MORGAN AND MORECAMBE OFFSHORE WIND FARMS: TRANSMISSION ASSETS

Annex 2.2 to Applicants' Response to Deadline 4 submissions from Statutory Consultees and other organisation: Fylde Borough Council (REP4-134)

Deadline: Deadline 5
Application Reference: EN020028

Document Reference: S_D5_2.2

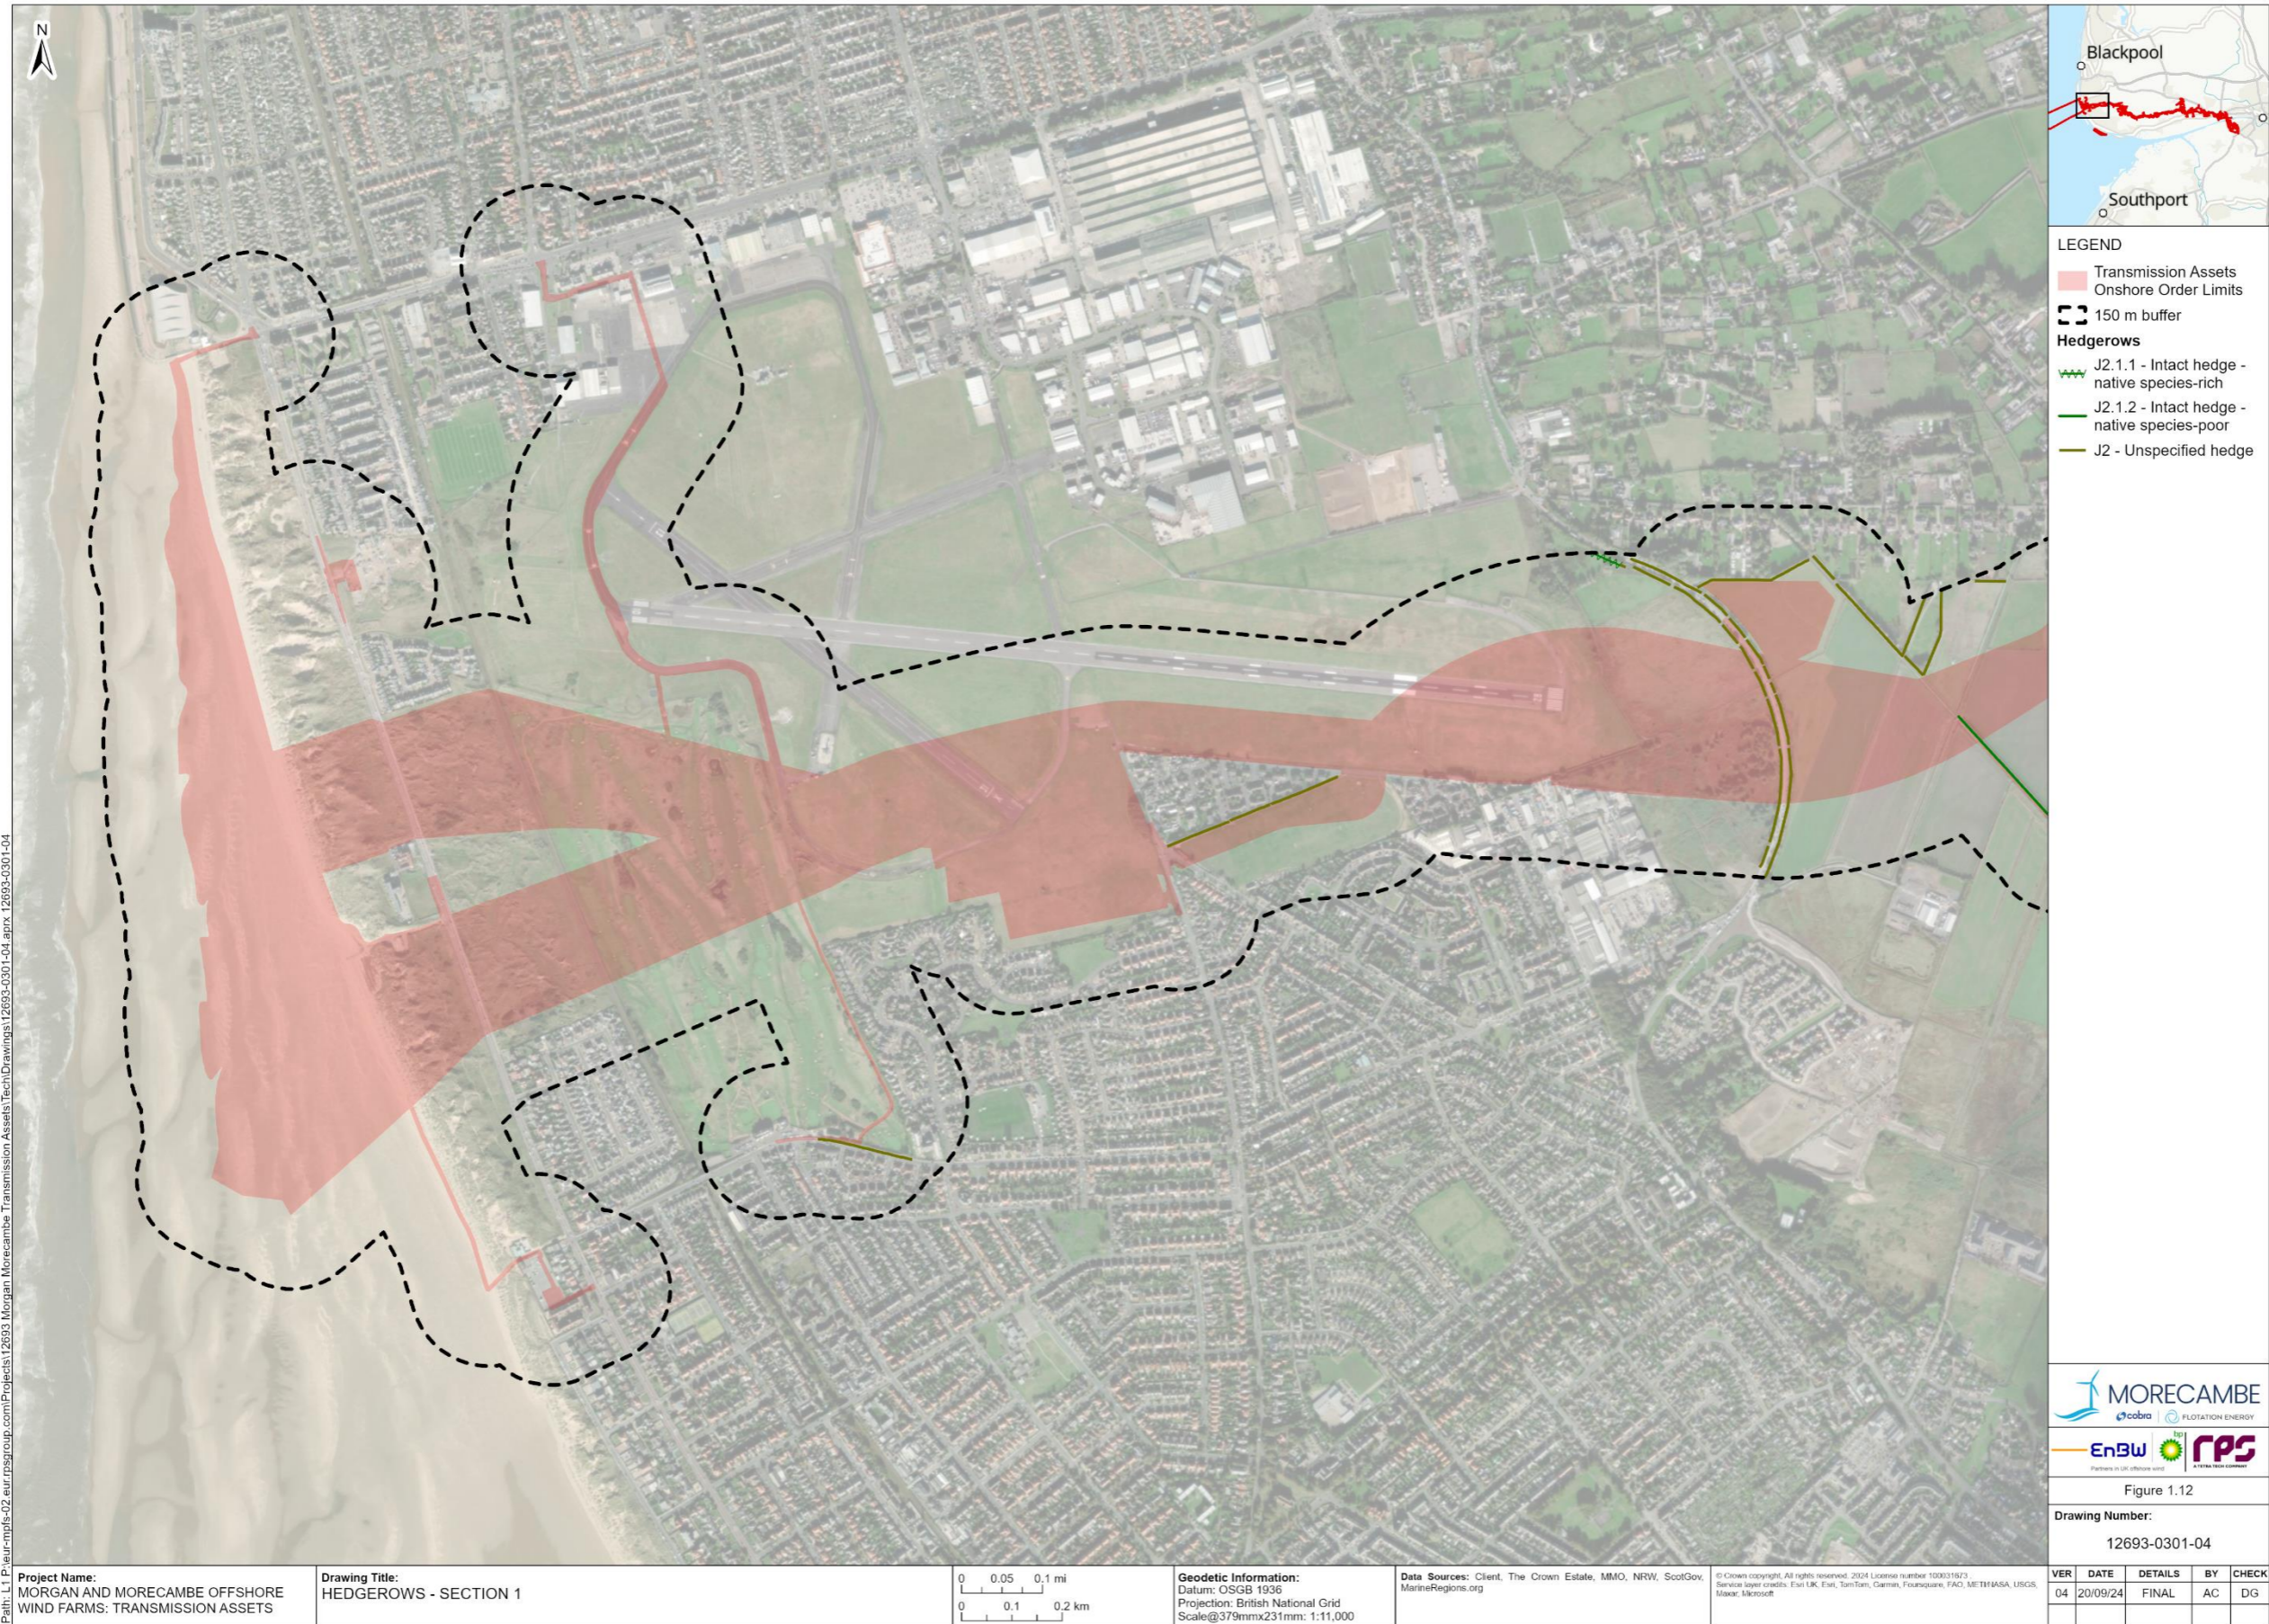
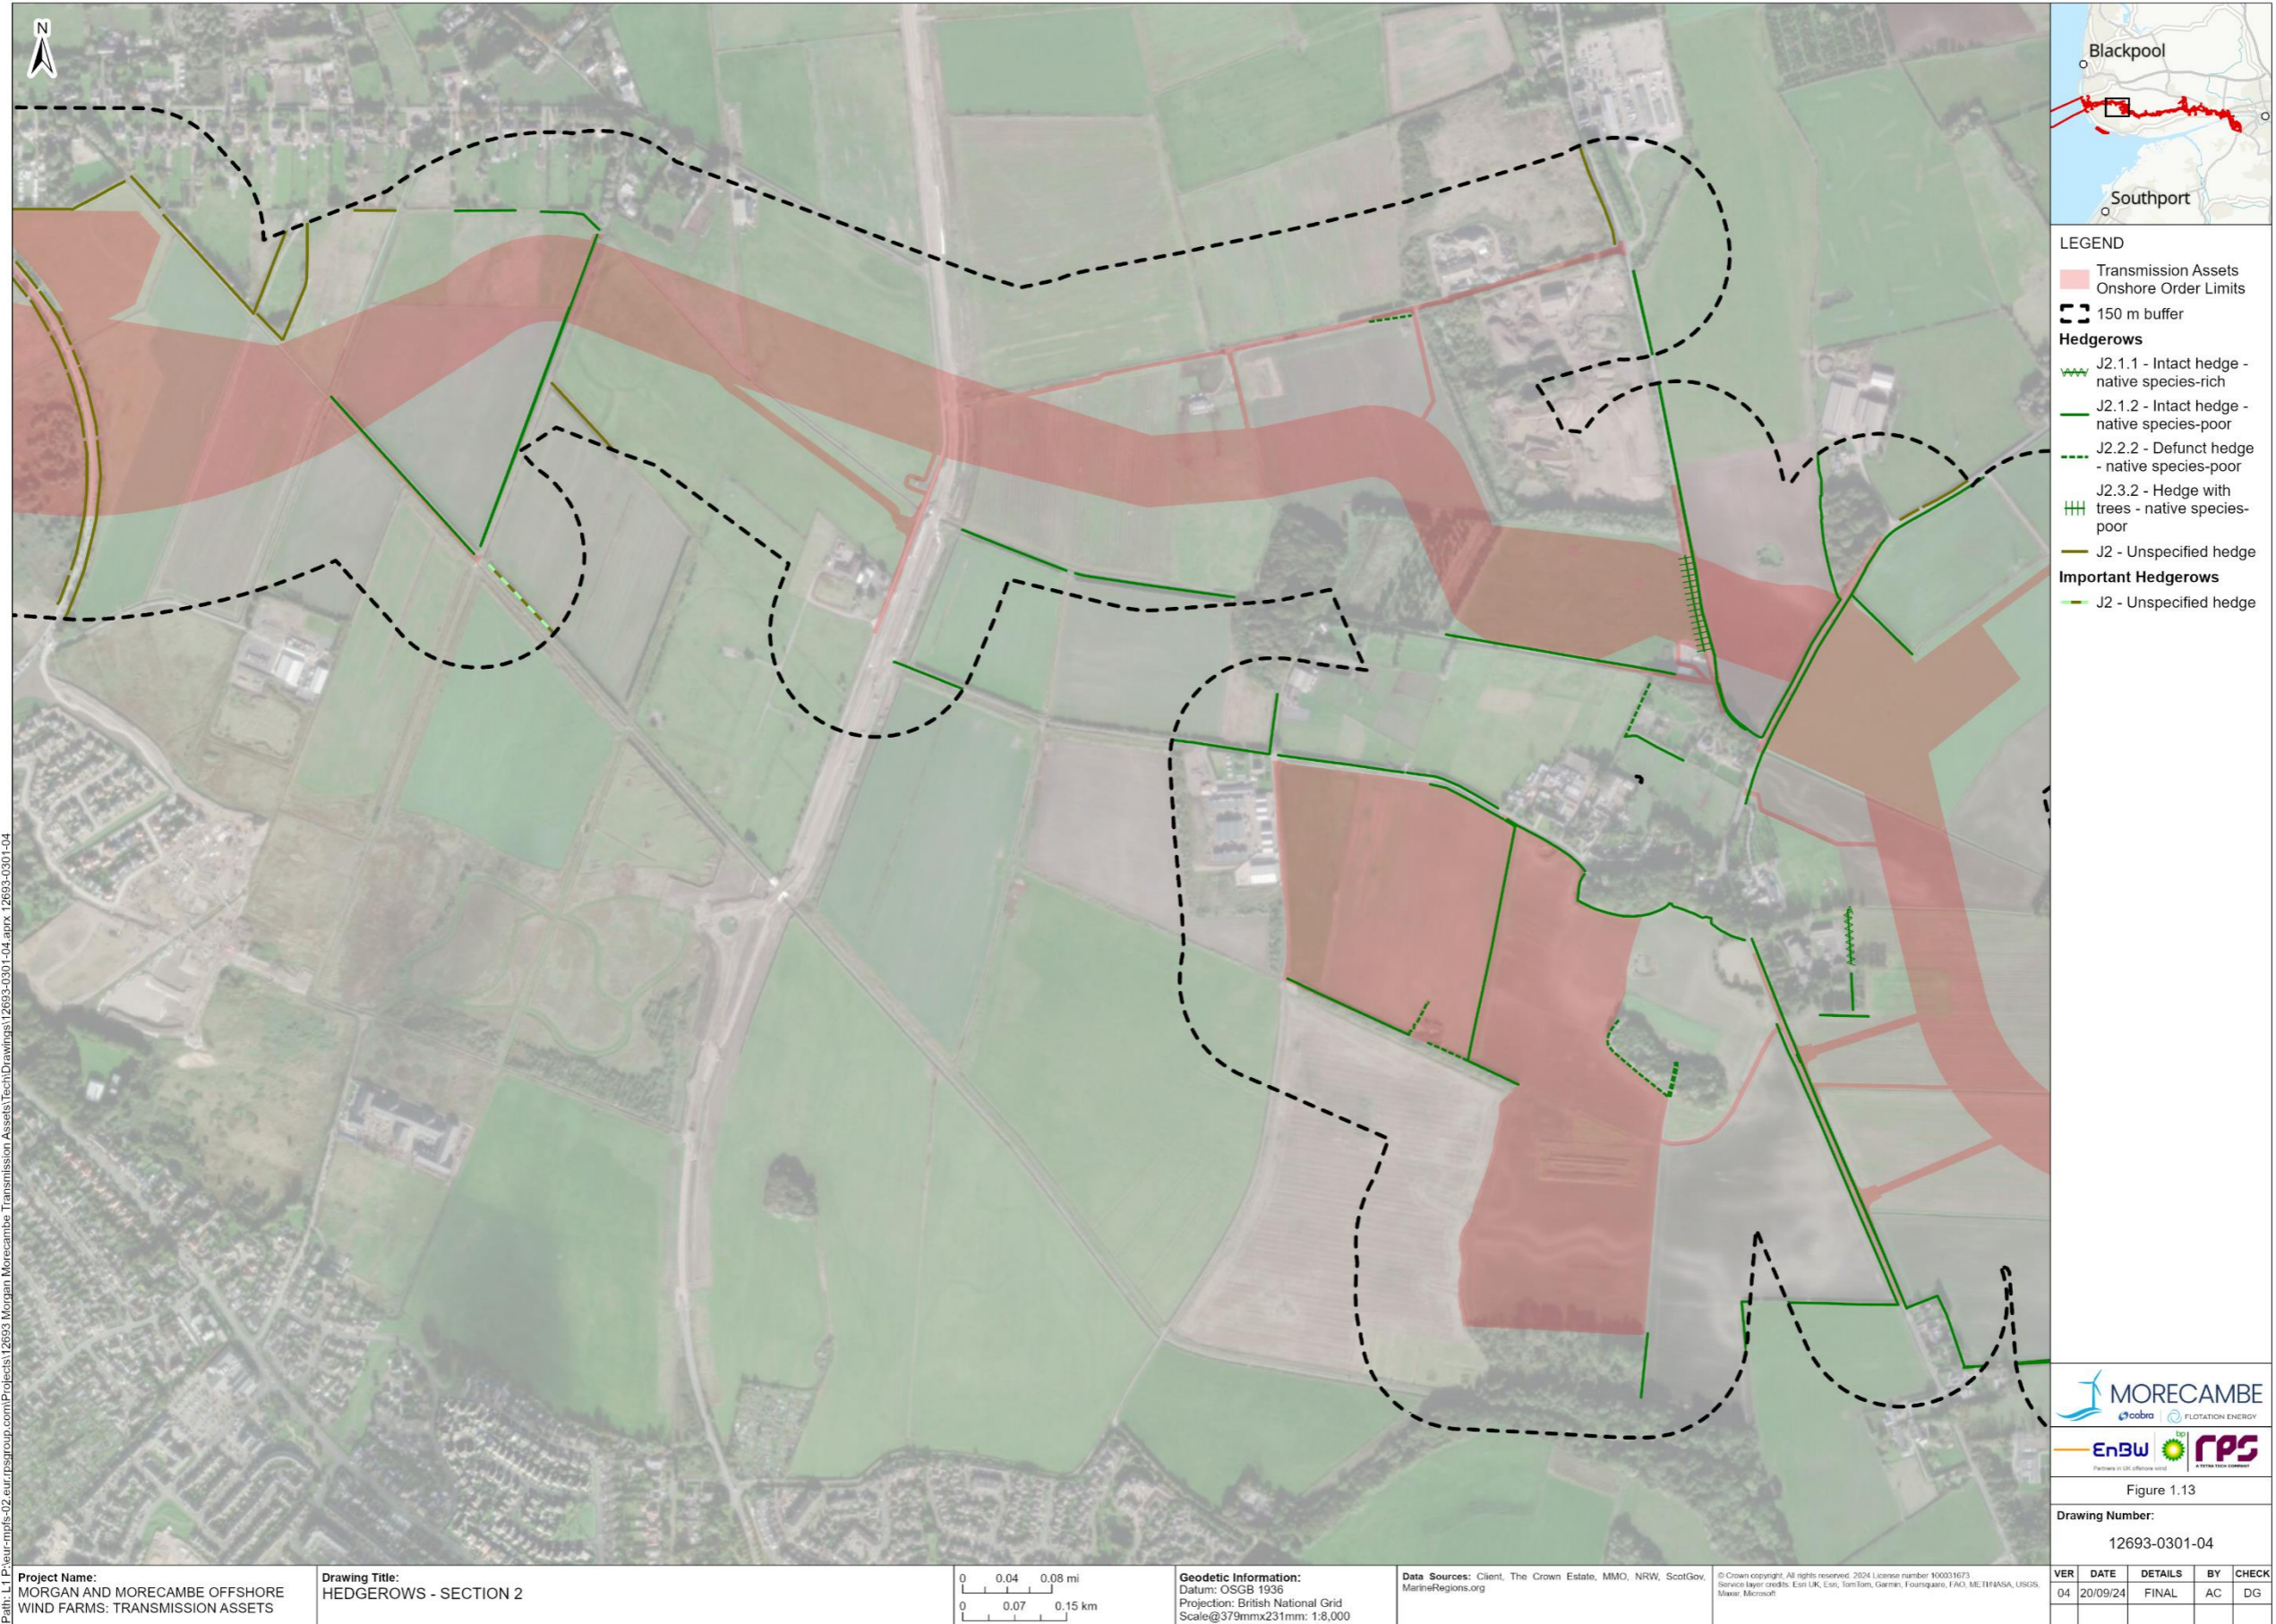
<p>REP4-134</p> <p>134.14</p>	<p>5.2 Scope of Hedge Removal</p> <p>5.2.2 The amount of hedgerow to be removed, as identified in Schedules 11A and 11B of the dDCO [REP3-009] is very large, at approximately 25km total. This is due to the large extent of the cable routing and Order limits significantly resulting in a greater and extended impact.</p> <p>5.2.3 Importantly, Section (4) of Article 35 of the dDCO allows for the removal of any hedgerow within the Order limits, in addition to those identified in Schedules 11A and 11B. FBC considers this to be unwarranted, inappropriate and not in accordance with Good Practice Point 6 of 'Advice Note Fifteen: drafting Development Consent Orders'</p>	<p>The Applicants have reviewed the wording of Article 35 against the Mona Offshore Wind Farm Order 2025 and consider that it is appropriate to update the drafting such that, unless otherwise agreed, Morgan can only remove important hedgerows that are identified in Schedule 11A and Morecambe can only remove important hedgerows that are identified in Schedule 11B. This is qualified by the inclusion of 'unless otherwise agreed', in light of the fact the Applicants have not been provided with full land access across the entire onshore Order limits and therefore it is possible that additional hedgerows may be identified when access to those areas of land is taken post consent. In the case of refusal,</p>

Reference	IP submission	Applicants' response
	<p>which requires all hedgerows affected by the proposed development to be identified within the Schedules.</p> <p>5.2.4 FBC requires that the applicants prepare a Schedule and plan in accordance with Good Practice Point 6 and that Article 36 of the DCO be updated to engage appropriately with these matters.</p>	<p>Morgan/Morecambe would be required to obtain a separate consent for removal of that important hedgerow.</p>
<p>REP4-134 134.15</p>	<p>5.3 Standards for Works to All Trees and Hedges</p> <p>5.3.2 Article 35 of the dDCO [REP3-009] allows for works to trees and hedges, including felling and removal, without any appropriate control.</p> <p>5.3.3 Neither the dDCO, nor the Commitments Register [REP3-013] make reference to any controls or standards in terms of how works under Article 35 would be carried out. A specification of works is therefore required.</p> <p>5.3.4 Section 5.11.27 of EN-1 includes a requirement for existing trees to be retained wherever possible and compensation provided where loss is unavoidable. It is entirely reasonable to extend this principle to require that works to retained trees to be carried out in such a way that harm to the long-term health of those trees is minimised.</p> <p>5.3.5 FBC therefore considers it appropriate to include control either within the DCO or Commitment Register, such as that works should be carried out in accordance with BS3998:2010 and BS5837:2012, and that tree health checks should be conducted by a suitably qualified Arboricultural Clerk of Works to satisfy the monitoring and supervision requirements within BS5837:2012.</p> <p>5.3.6 FBC requires like for like replacement for hedge loss, to achieve this recording of the hedge removal, tree/shrub species and soil types needs to be fully recorded. This is consistent with EN-1, FBC Local Plan Policies ENV1 and ENV3, and 'Advice Note Fifteen: drafting Development Consent Orders'.</p>	<p>The Applicants have prepared an outline Arboricultural Method Statement (S_D5_10) which is secured through Requirement 8 of Schedules 2A and 2B to in the draft DCO (C1/F07). Measures include but are not limited to:</p> <ul style="list-style-type: none"> Any further surveys required would be undertaken in accordance with BS5837:2012 All works to trees shall be carried out in accordance with BS3998:2010 and latest arboricultural best practice. All tree work shall be carried out by suitably qualified, competent and insured arboricultural contractors in accordance with Arboricultural Association Standard Conditions of Contract and Specifications for Tree Works (2008) Edition Measures to ensure tree health is considered and maintained throughout construction (such as construction exclusion zones and tree protection fencing) <p>The Applicants have also updated Section 1.6.3 of the Outline Ecological Management Plan at Deadline 5 (REF) to provide further clarity of the measures that would be in place to ensure the removal of and works to hedgerows are minimised. The measures include but are not limited to:</p> <ul style="list-style-type: none"> All hedgerows and trees retained within, or on the boundary of, construction work areas will be appropriately protected from damage during the construction works. A theoretical root protection area (RPA) is to be calculated, to ensure hedgerows and associated trees are not harmed by development activities

Reference	IP submission	Applicants' response
		<ul style="list-style-type: none"> Ensuring that all hedgerow removal works will comply with 'BS 5937:2012 Trees in relation to design, demolition and construction – Recommendations' Where hedgerow removal is proposed, works will be undertaken under ecological supervision. <p>In addition, paragraph 1.4.2.3 of the Outline Landscape Management Plan (REF) states that one of the main objectives of the landscape proposals is to reinstate land and plant replacement trees, hedgerows and other vegetation where practicable.</p>
REP4-134 134.16	<p>6 Ecology (Excluding dunes)</p> <p>6.1.2 FBC has provided separate comments relating to the sand dunes area within this written response.</p> <p>6.1.3 FBC notes the Action Points arising from ISH2 and ISH3 as they relate to ecology and will review the new and updated information as it becomes available. FBC expects to provide further written submissions, particularly in response to the range of Outline Management Plans relevant to ecological matters.</p> <p>6.1.4 FBC will also continue to engage with the applicants on matters relating to ecology. FBC can confirm that a series of meetings have been schedule ahead of Deadline 5 which should allow a substantively complete Statement of Common Ground [SoCG] to be submitted at Deadline 5, insofar as it relates to ecology.</p> <p>6.1.5 However, FBC also notes ongoing engagement between the applicants and key ecological consultees, notably Natural England and the Environment Agency. FBC notes with some concern the range of outstanding issues, including in relation to matters which have been a point of either disagreement or slow progress since at least 2023.</p> <p>6.1.6 The remainder of this section provides a summary of oral submission made by FBC at ISH2 and ISH3 as they relate to ecology.</p>	<p>The Applicants can confirm an SoCG meeting was held with Fylde on 5th September.</p> <p>The Applicants can confirm that there is ongoing engagement with EA and NE to discuss these matters. We consider this level of engagement to be typical of a project of this type and size and not anything of concern. Progress has been made on these issues and we do not consider this to be slow.</p>
